REQUEST

Current Zoning: OFC (office flex campus) and CG (general commercial)
Proposed Zoning: NS (neighborhood services)

Approximately 0.45 acres located on the east side of The Plaza, north of Mimosa and south of Mecklenburg Avenue.

The petition proposes to allow all uses in the NS district in an existing building, subject to prohibited uses. The site is located just outside the Plaza-Midwood Historic District.

Revised Site Plan 10.17.22

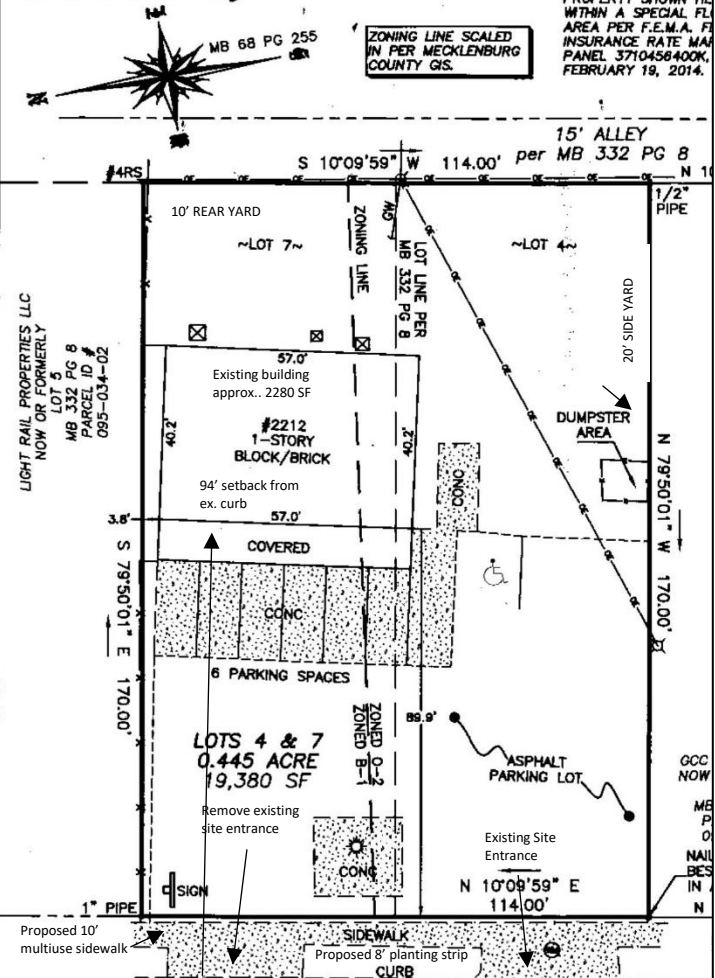
- ~~1. Remove "if needed" and "is needed" at the end of conditional notes shown below:~~ Addressed

- Vehicular access to Site shall be via one of the current driveways as shown on the site plan
- Close northern driveway
- All improvements will be approved and constructed before the site's first building CO is issued **if needed**
- commit to remarking current bike lane pavement markings to a dedicated right turn lane, a bike ramp near south property line per CLDSM 10.43 to transition bicyclists from separated bike lanes to multi-use path and extending the 10-foot multi-use path to the southern property.
- Commit to striping and dedicated right turn arrow per CDOT pavement marking standards
- commit to dedicating 50-feet of right-of-way if it does not currently exist.
- fee simple conveyance of all rights-of-way to the City before the site's first building certificate of occupancy is issued **is needed**

- ~~2. All applications for grading, building, demolition, land use, change of use or rezoning permits on all property, except single family development shall require a tree survey. The survey shall identify all trees of eight inch dbh or greater and all planted trees of two inch caliper or greater and six feet in height that grow partially or wholly within the city right of way.~~ Addressed

- ~~3. Commit to providing a minimum 10-foot Class C buffer along property lines abutting residential zoning and/or use.~~ Addressed
